Lead Local Flood Authority

RE: WA/18/26/PL - Wick Football Club, Lyminster Road, Littlehampton, BN17 7LS

This is a full application for Change of surface from grass to artificial turf and erection of new 2.5m acoustic fencing. Is in CIL Zone 2 (zero rated) as all other development.

At present we **object and require additional information covering the below matters:**

EDGE DETAIL

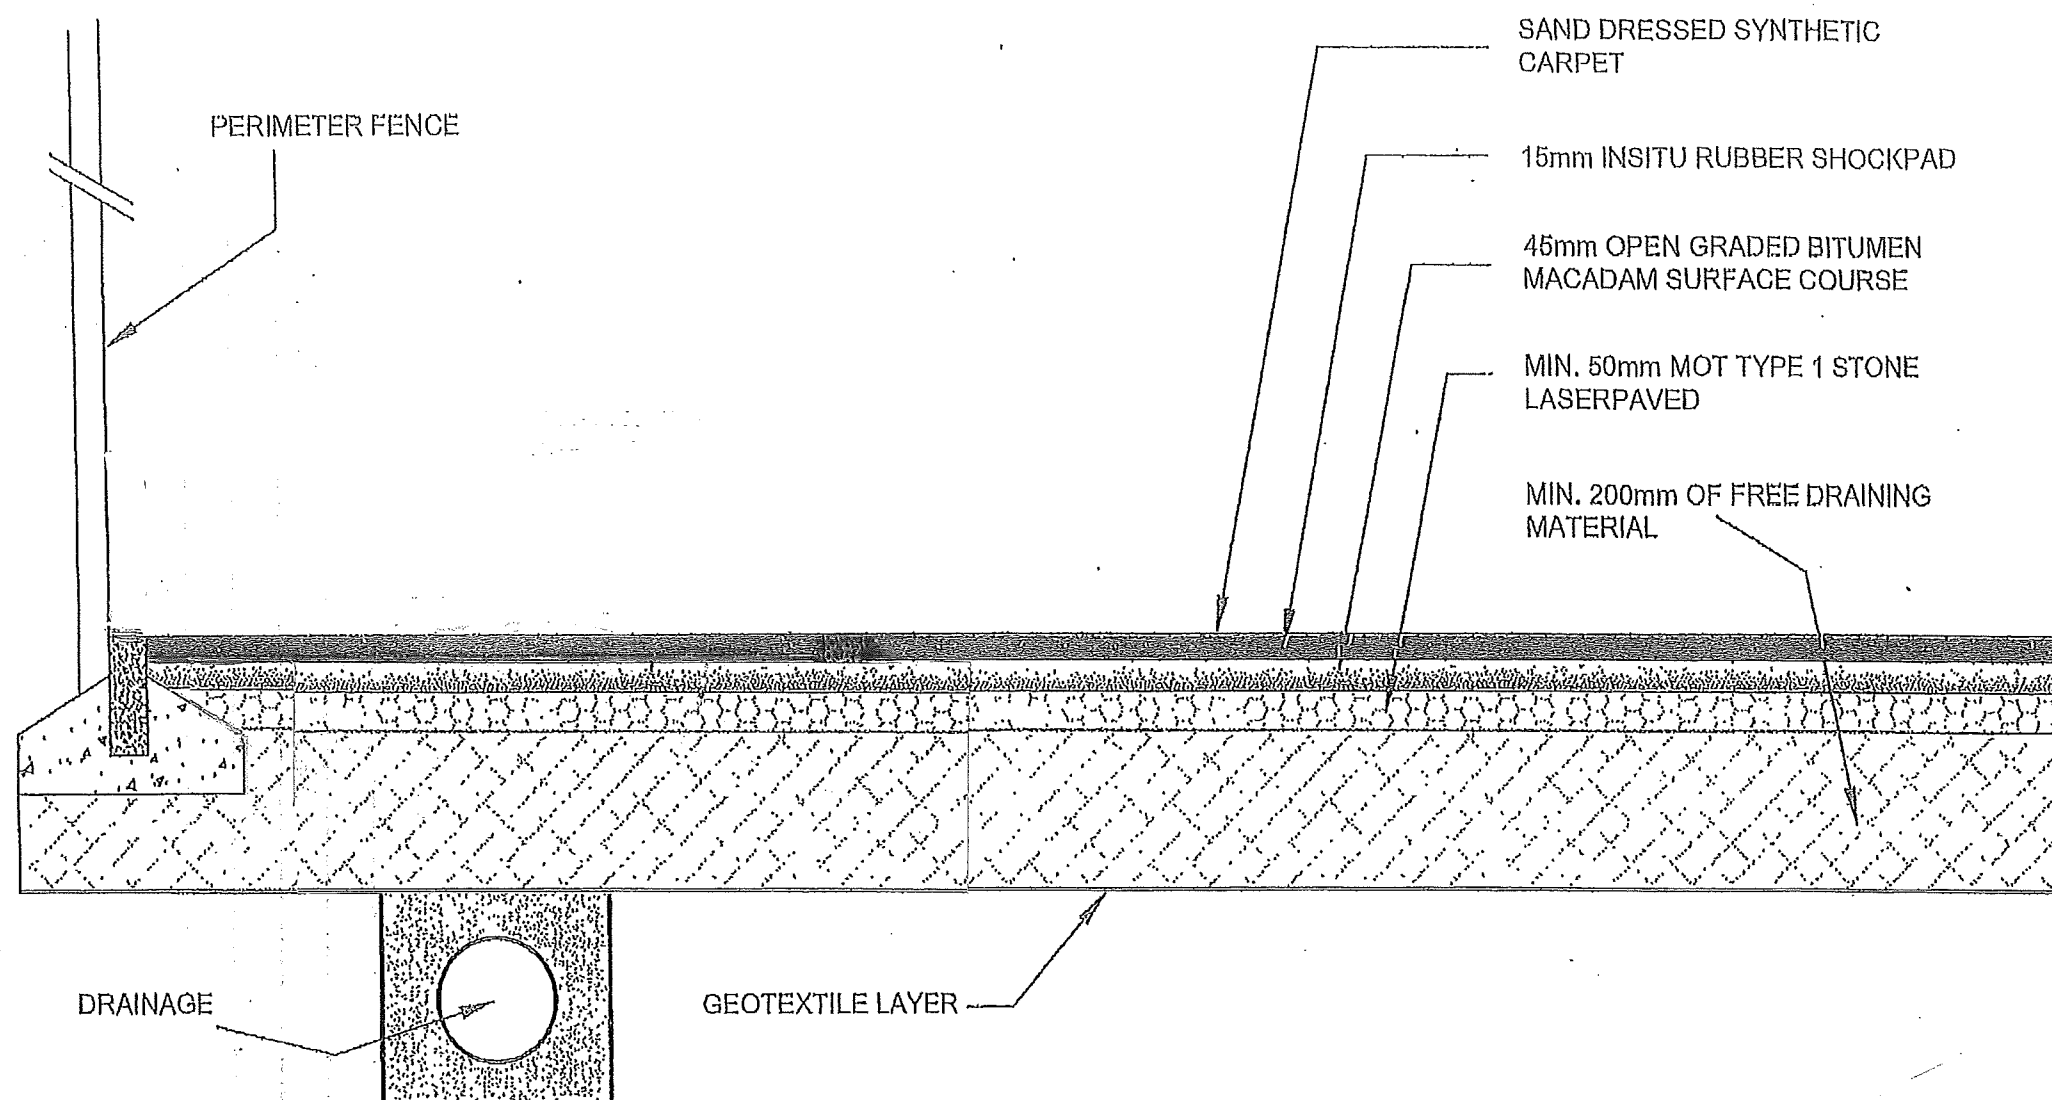
1. Provide evidence via a detailed cross section that there is a like for like permeable surface being proposed demonstrating no net detriment or likely betterment compared to the existing scenario.
